**FRASERS PUTNEY STAGE 1 PHASE 1
APARTMENT BLOCK 1**

ACCESS REVIEW

Morris Goding Accessibility Consulting

16th April 2012

TYPICAL FLOOR PLAN - 2 BEDROOM

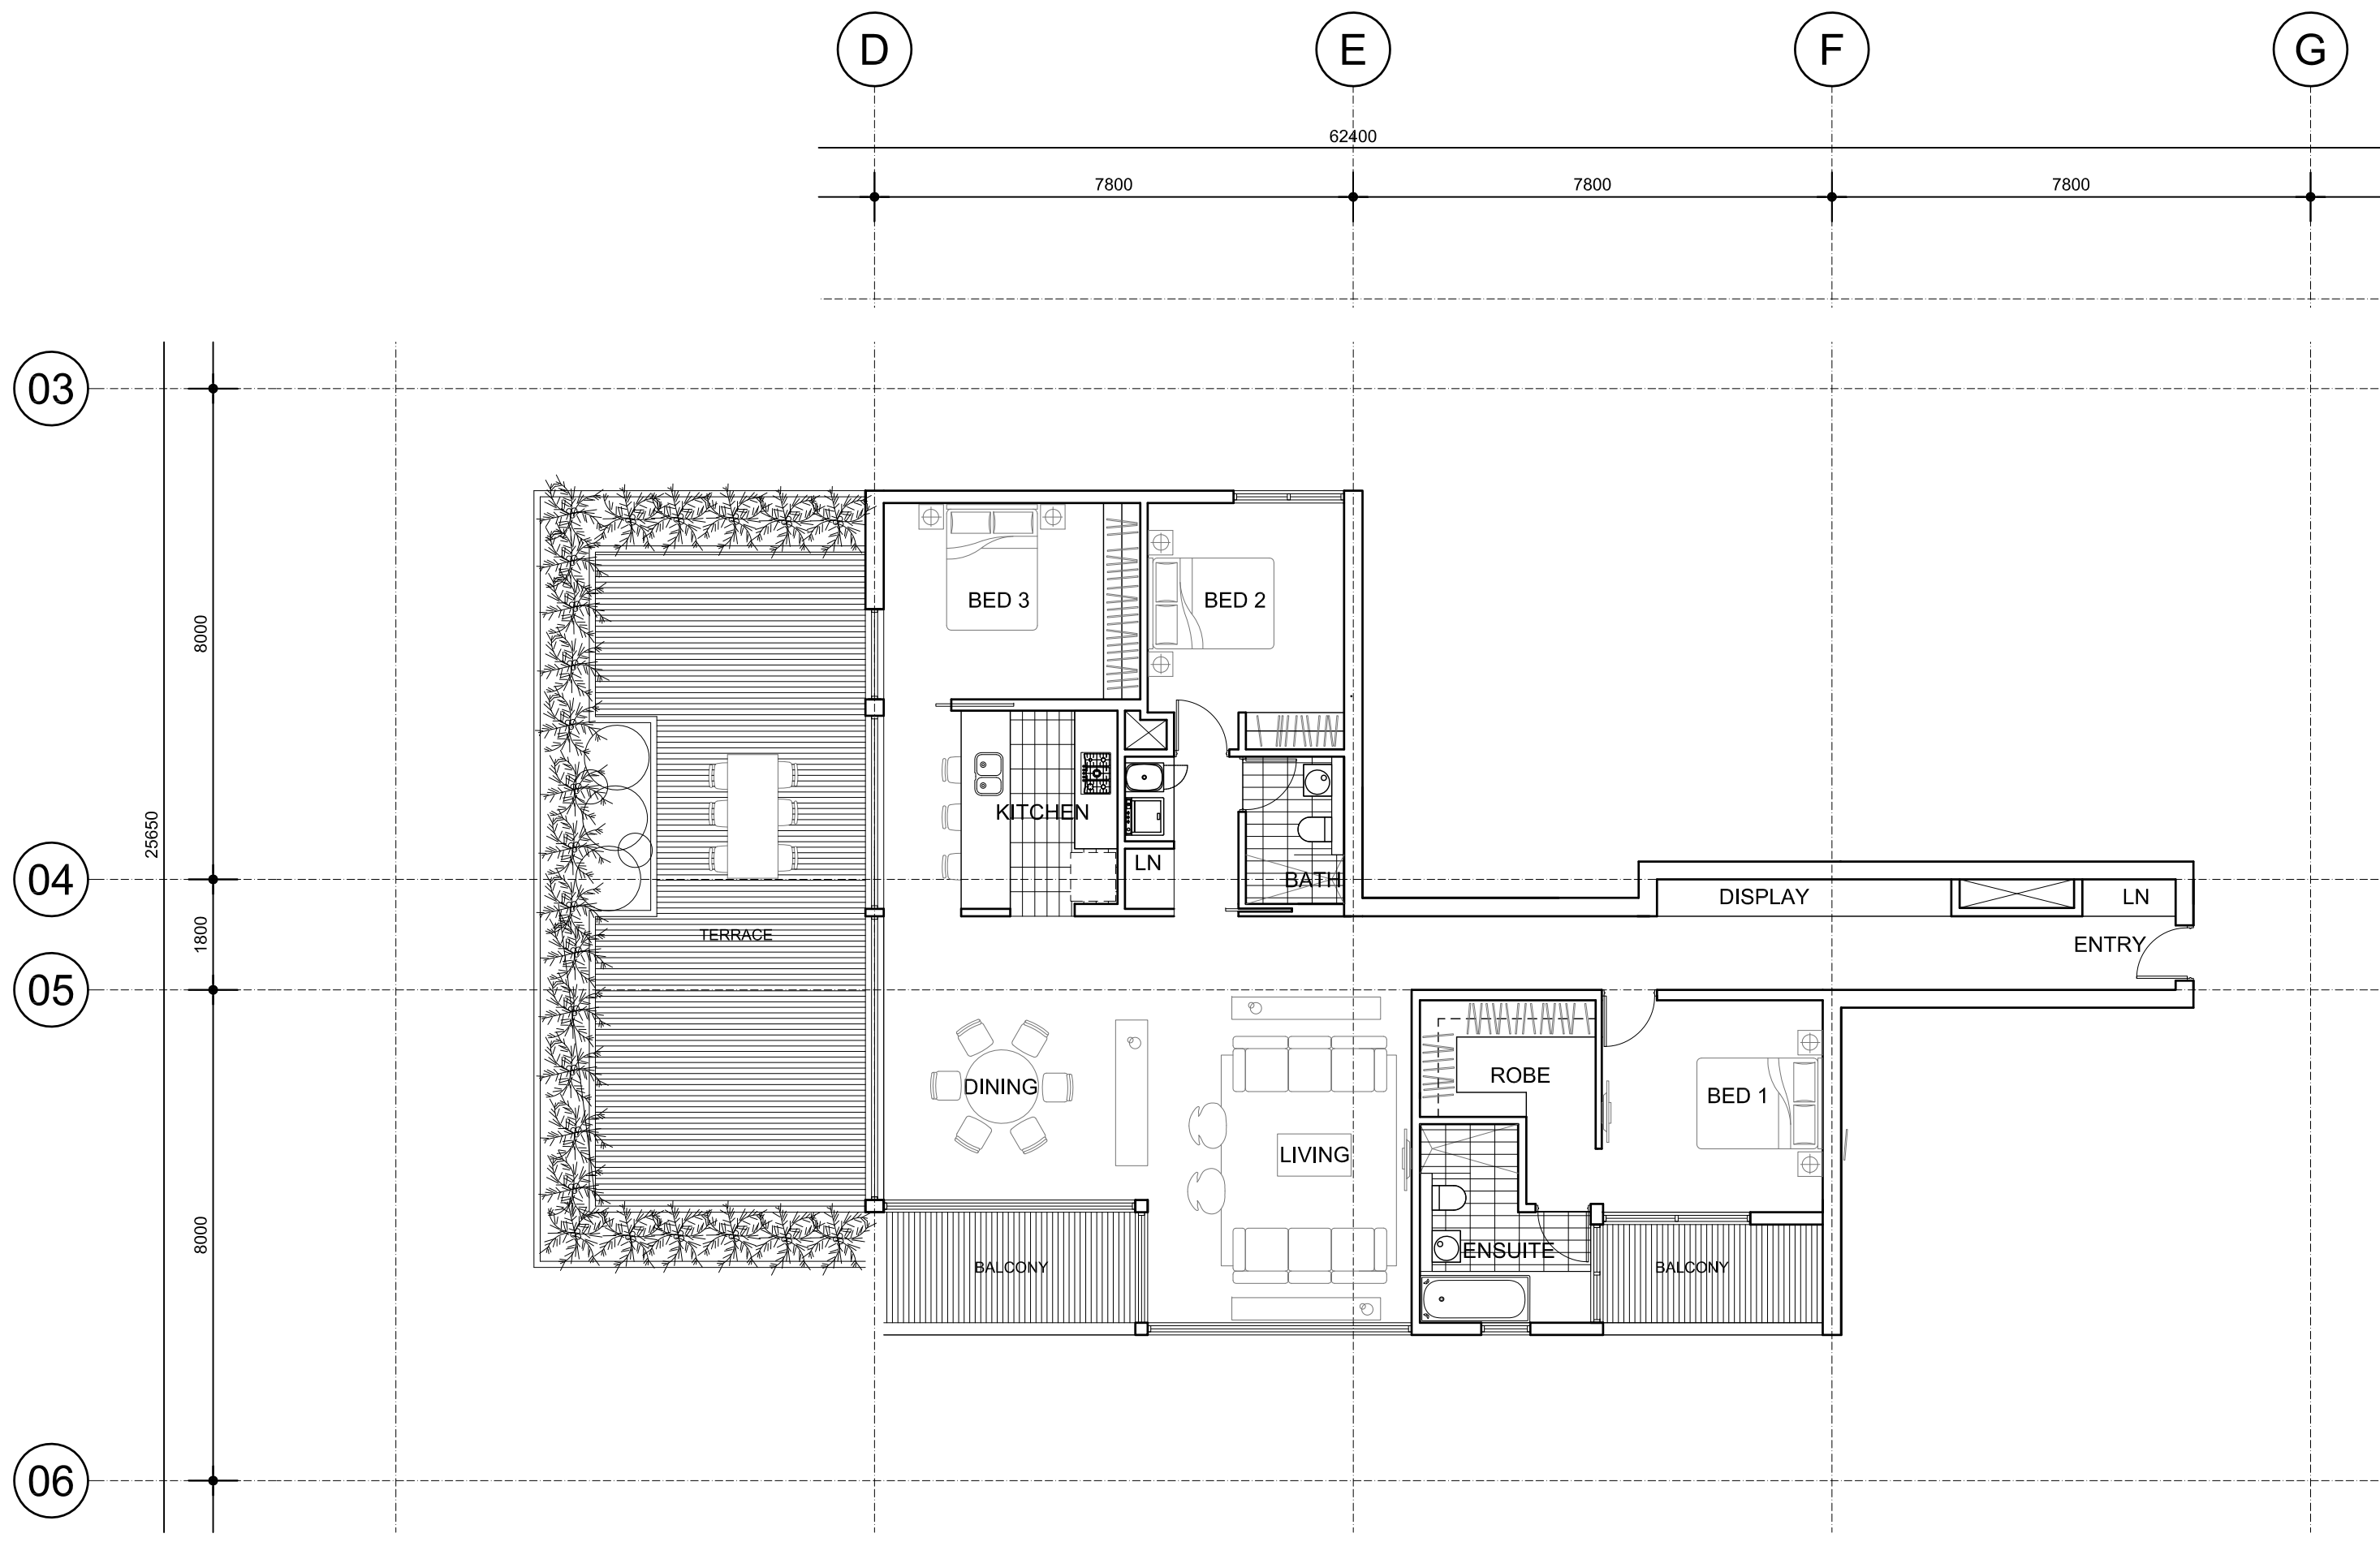
- (i) Provide drawings of the adaptable unit in its pre and post adaptation stage.
- (ii) The entry door to have 850mm clear width (920mm door leaf) and provide a 510 530mm latch side clearance on the external and internal side of the door.

- (iii) Internal doors (main bedroom, adaptable bathroom, laundry) require 820mm clear width with provision for suitable door circulation spaces to comply with AS1428.1:2009.

- (iv) Provisions for internal door circulation areas to comply with AS1428.1:2009.
- (v) The bedroom requires internal dimensions of 3.6m x 3.6m, outside the robe area.

- (vi) Bathroom (shower, toilet, wash basin) to comply with circulation area requirements of AS1428.1:2009 ie. provide an area of 2300mm x 1900mm around the WC pan. The wash basin to sit outside this area, and if needed only encroach into this area by 100mm (max). The shower area requires 2500mm x 1600mm.

- (vii) The kitchen is required to have a clearance of 1550mm between base cabinets. Provide work bench space (800mm min. width) adjacent to refrigerator, cook top, oven & sink which could be replaceable/adjustable in height.

- (viii) The living area should have clear area of 2250mm minimum diameter after the furniture has been placed will satisfy this requirement.
- (ix) The laundry area to have a circulation area in front of the laundry appliances of 1550mm in diameter.
